## Notes of 2/15 MMC Site Plan Review Meeting (CMP/Detours)

Key points from the 2/15/18 Site Plan Review meeting with MMC:

### **Congress Street Closure and associated detours/emergency access (based on the revised docs and plans attached to this e-mail from Gorrill-Palmer)**

**CMP - East Tower and Visitor Garage (based on revised CMP as attached from Turners)**

**MMC HOSPITAL EXPANSION  
 EAST TOWER OVERBUILD  
 STRUCTURAL STEEL  
 TRUCK ROUTE FROM I-295N TO MMC SITE ON  
 WESCOTT STREET  
 1-295 N TO WASHINGTON AVE. TO CONGRESS  
 STREET TO ELLSWORTH STREET TO  
 WESCOTT STREET SITE**

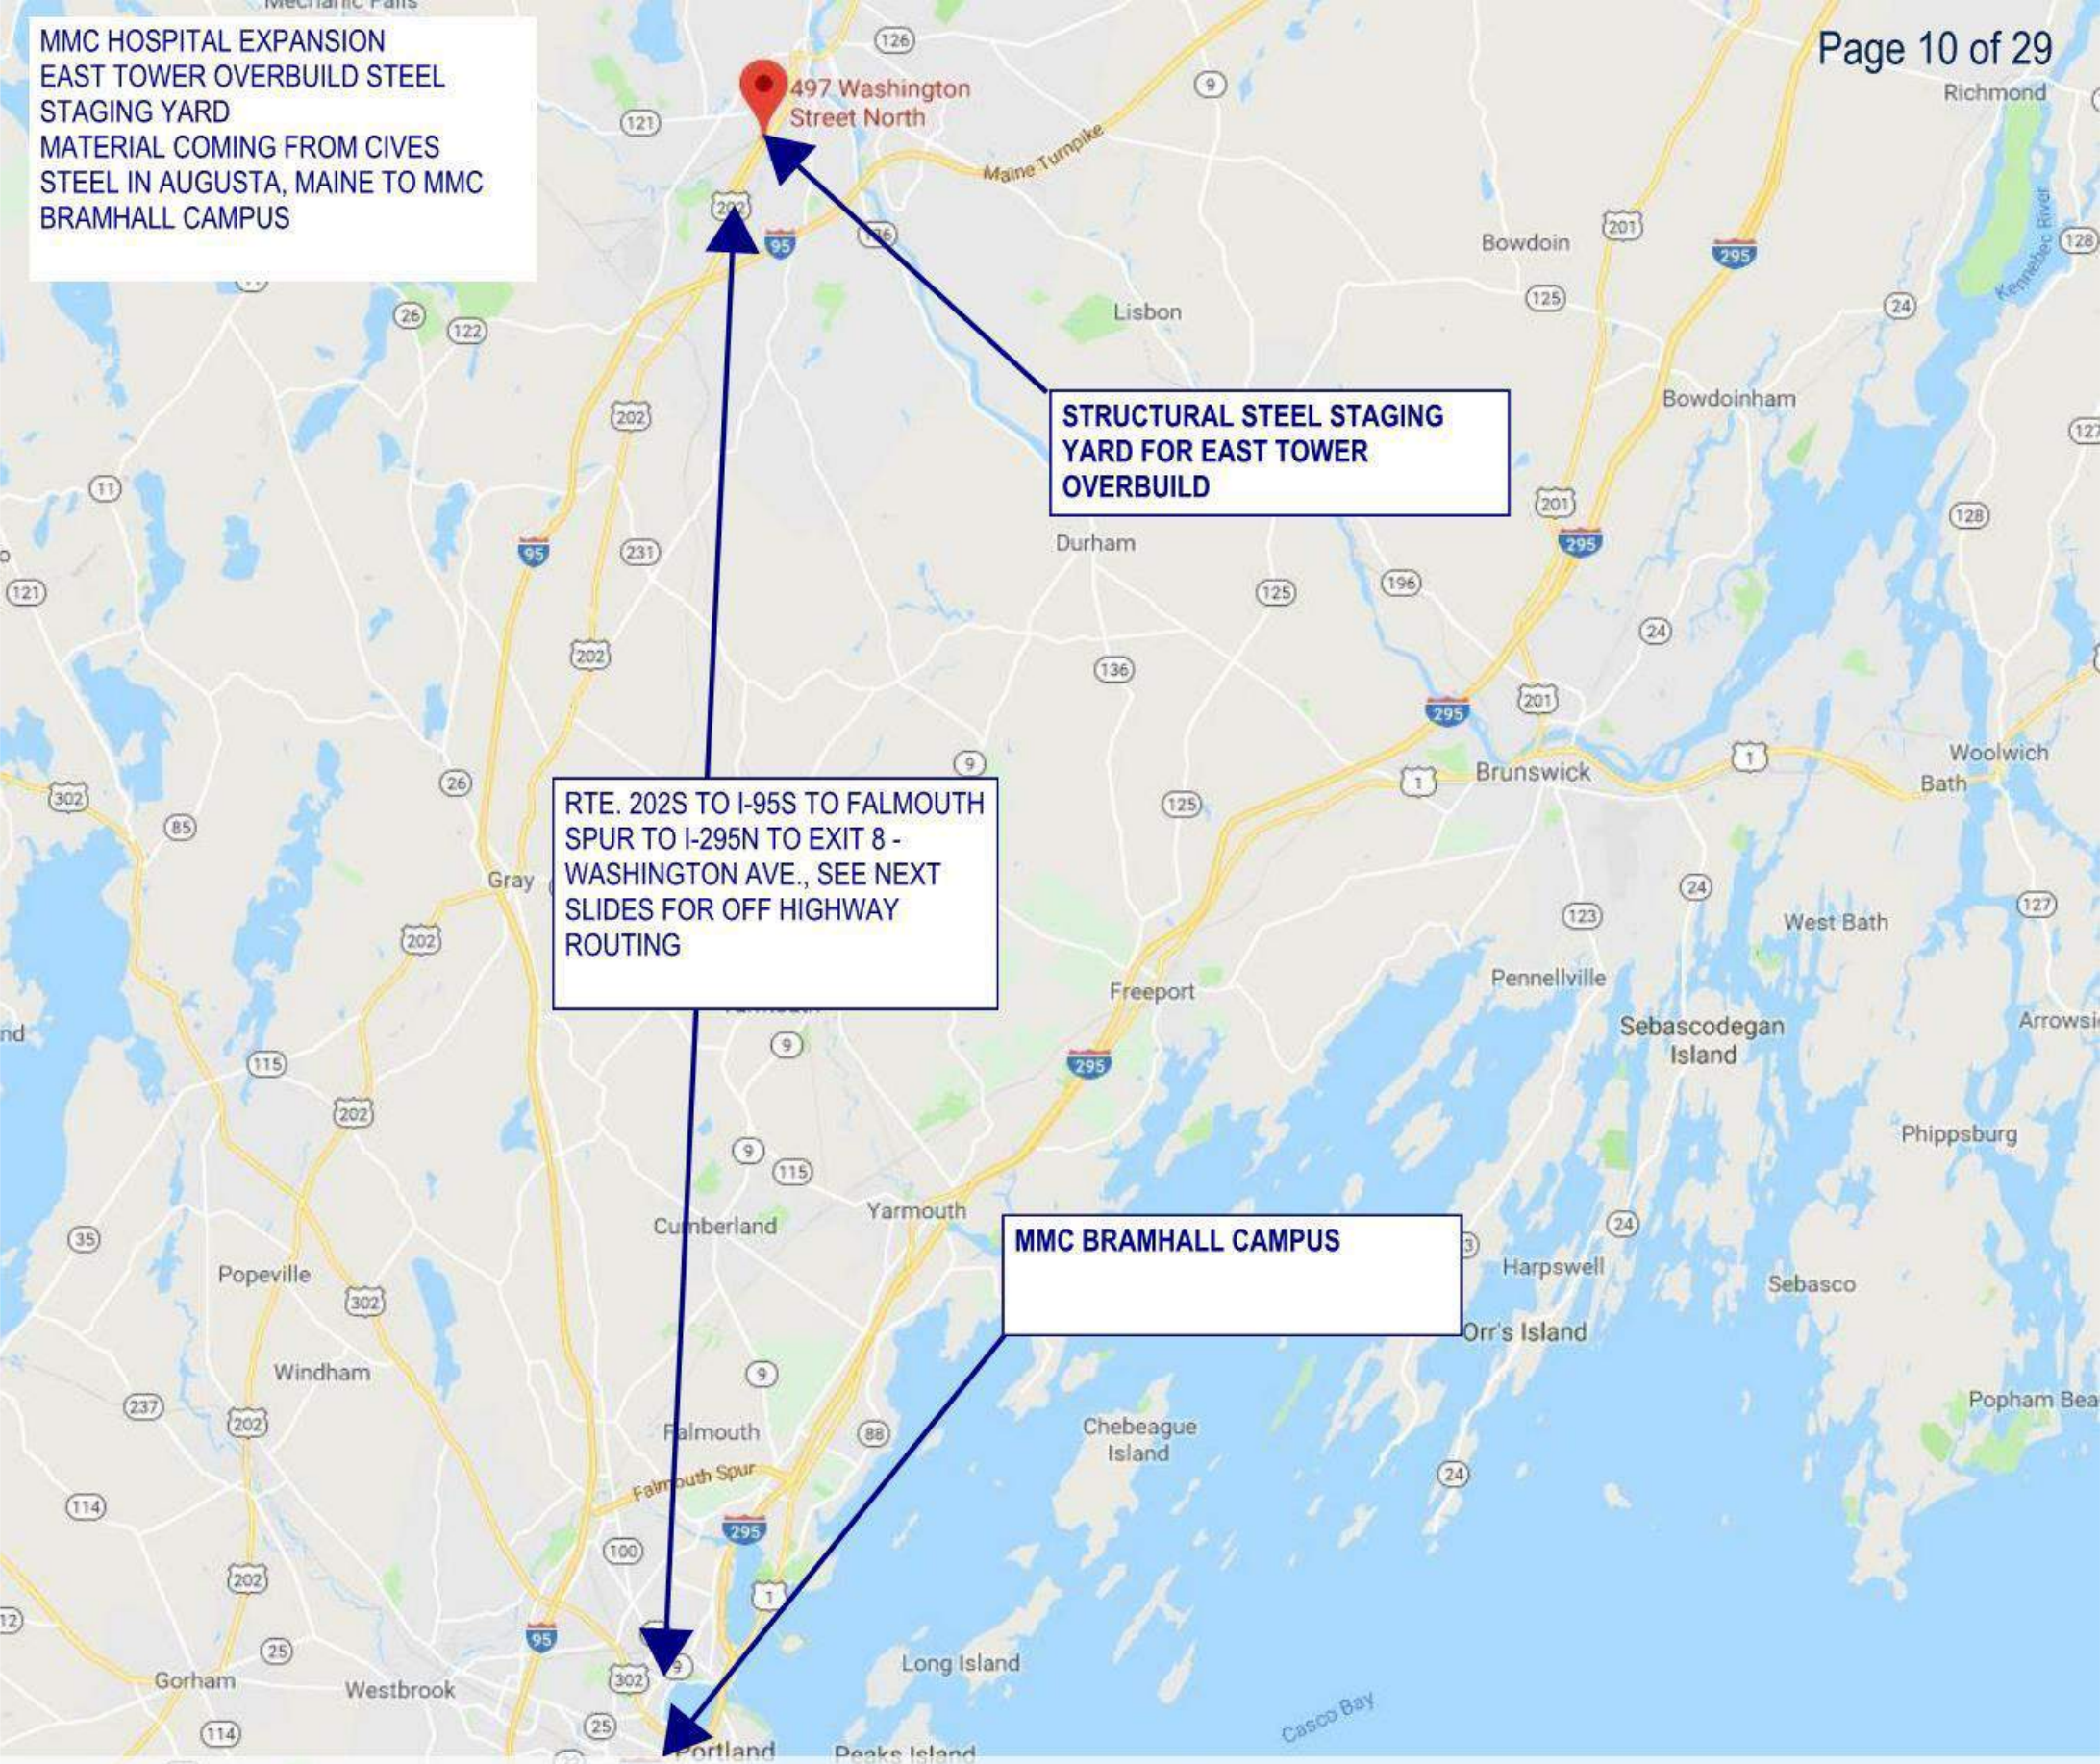
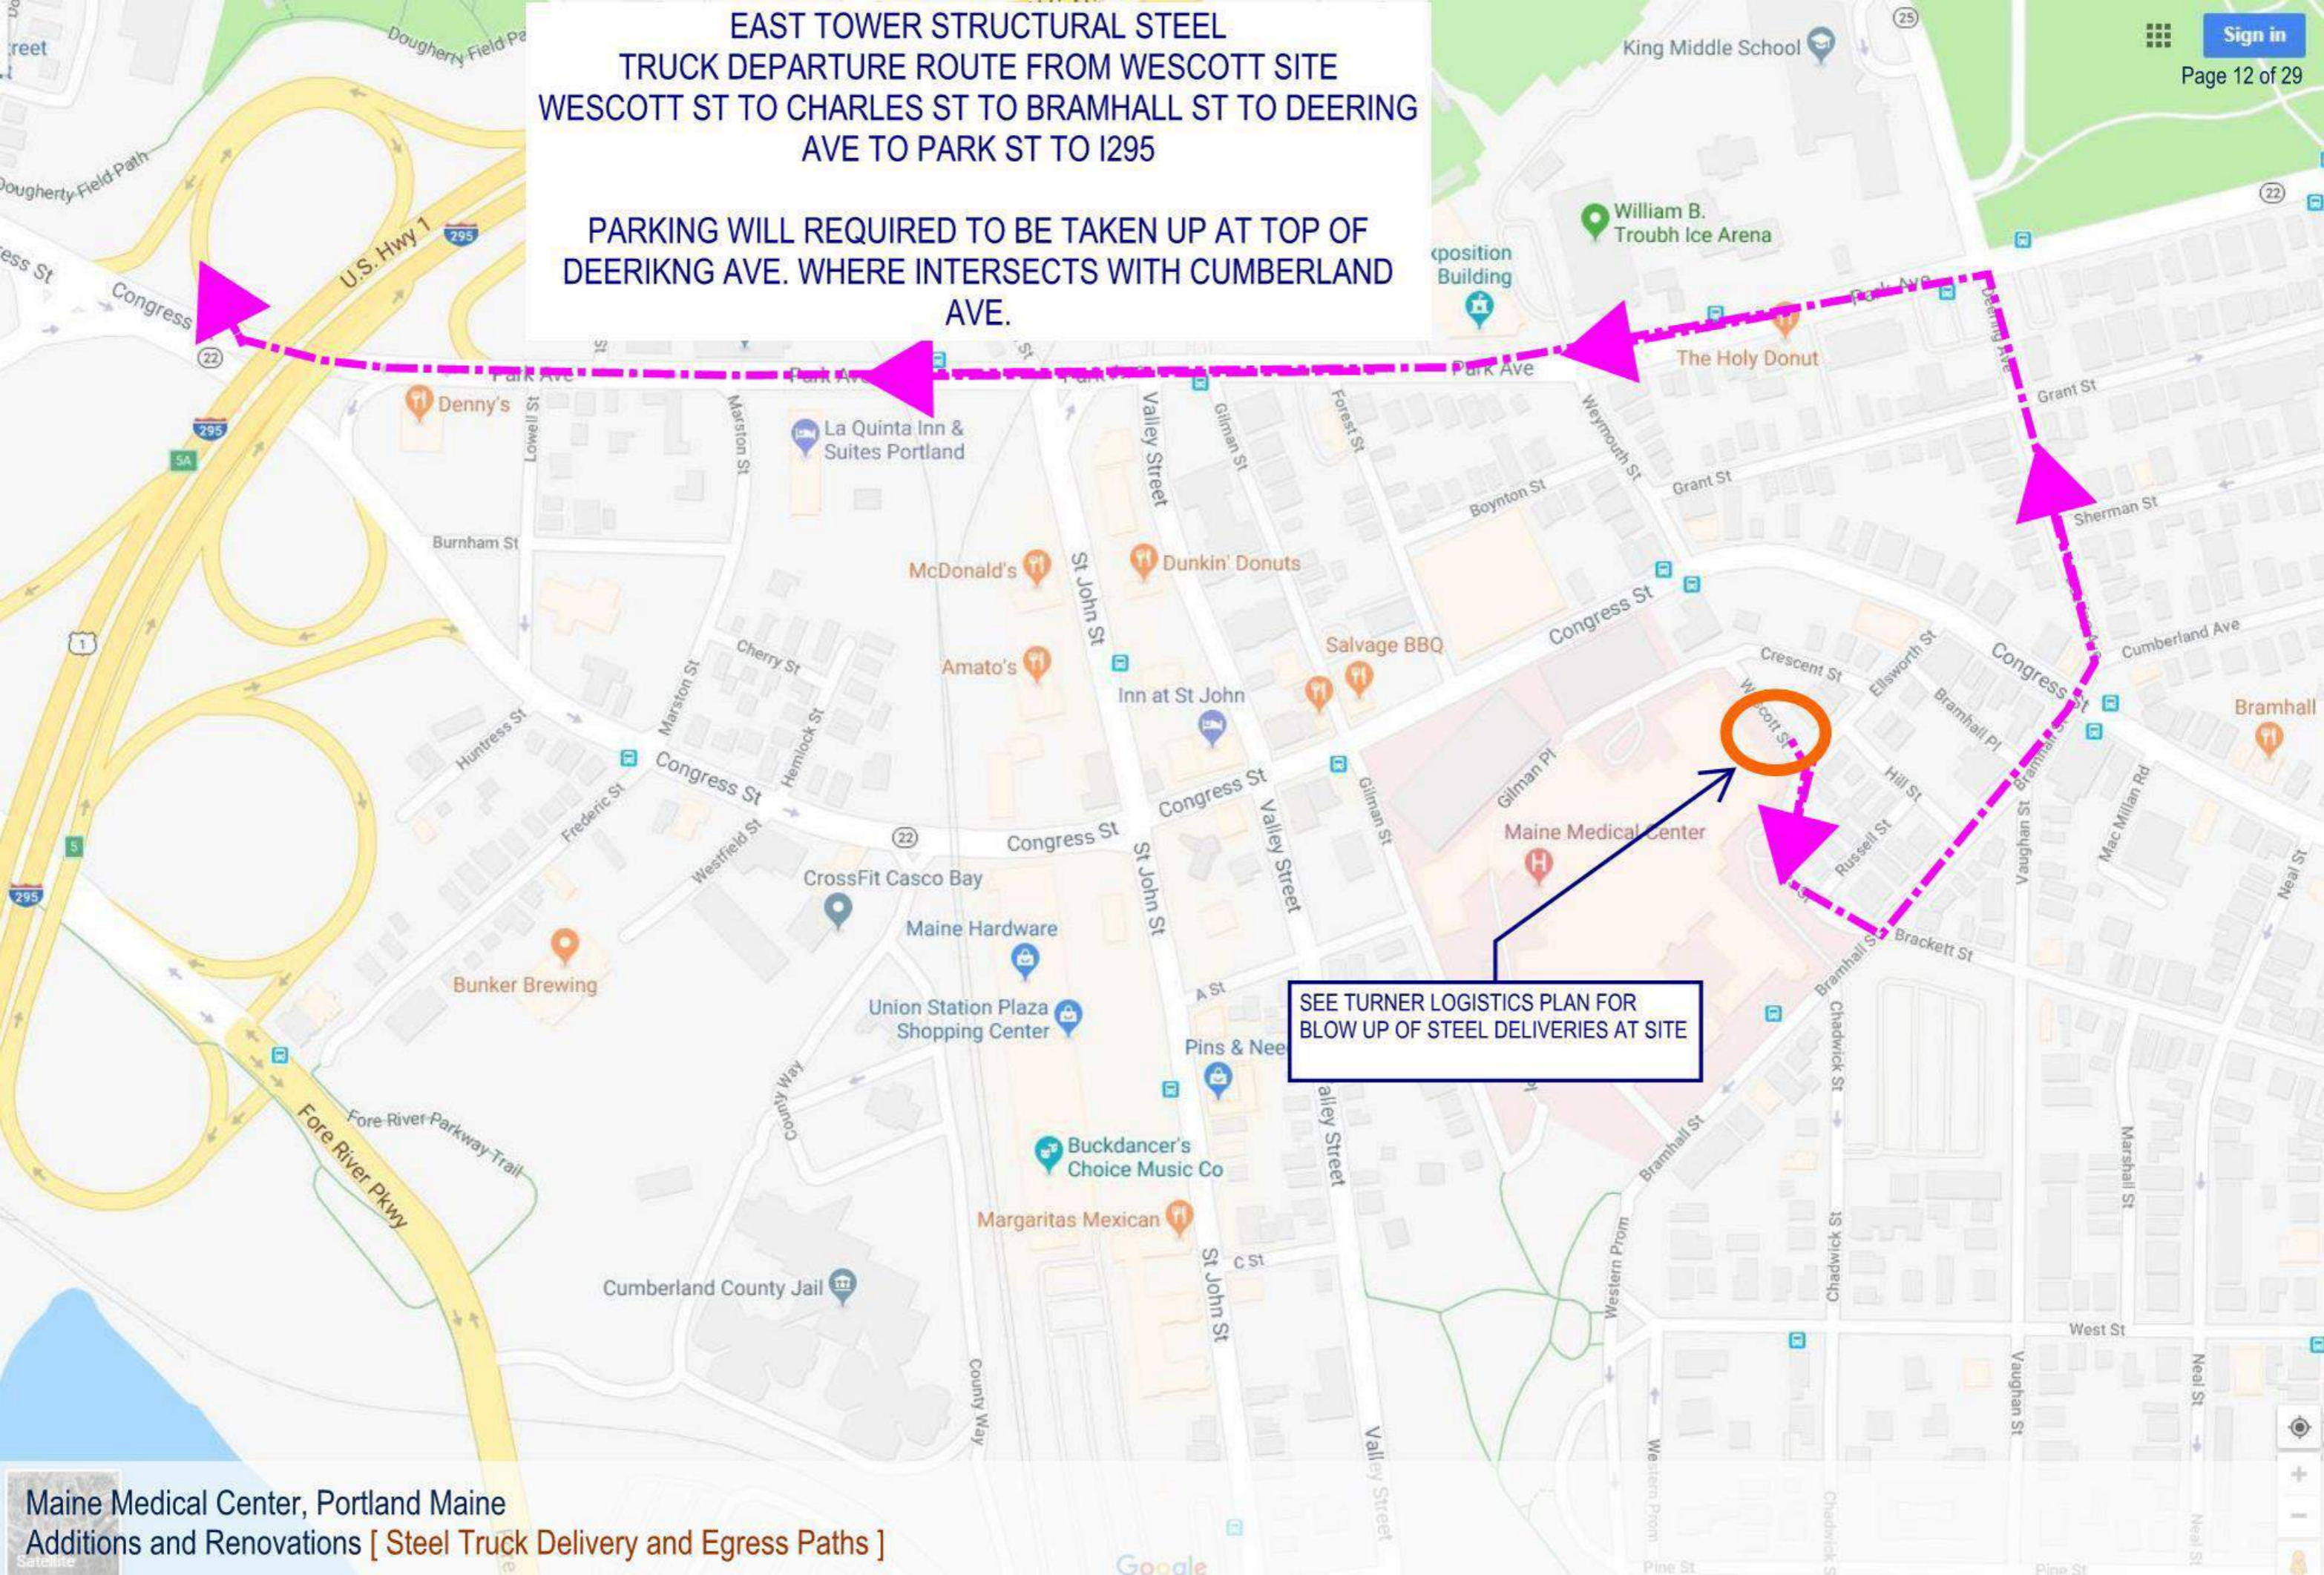
- Reviewers questioned the proposal to route steel deliveries (from North, June 4 to June 28, starting at 5am) along Washington Ave and Congress
  - City staff advised route should avoid Washington completely due to planned construction work

- Route must avoid downtown Portland and Congress
  - Keep delivery vehicles on I295 longer - maybe I295 to Forest /Park ? Deering; maybe Fore River Parkway

- Turners will speak to the trucking company again and get back to us
- Police stressed need for ongoing monitoring and process for making changes to delivery and detour routes after closure starts
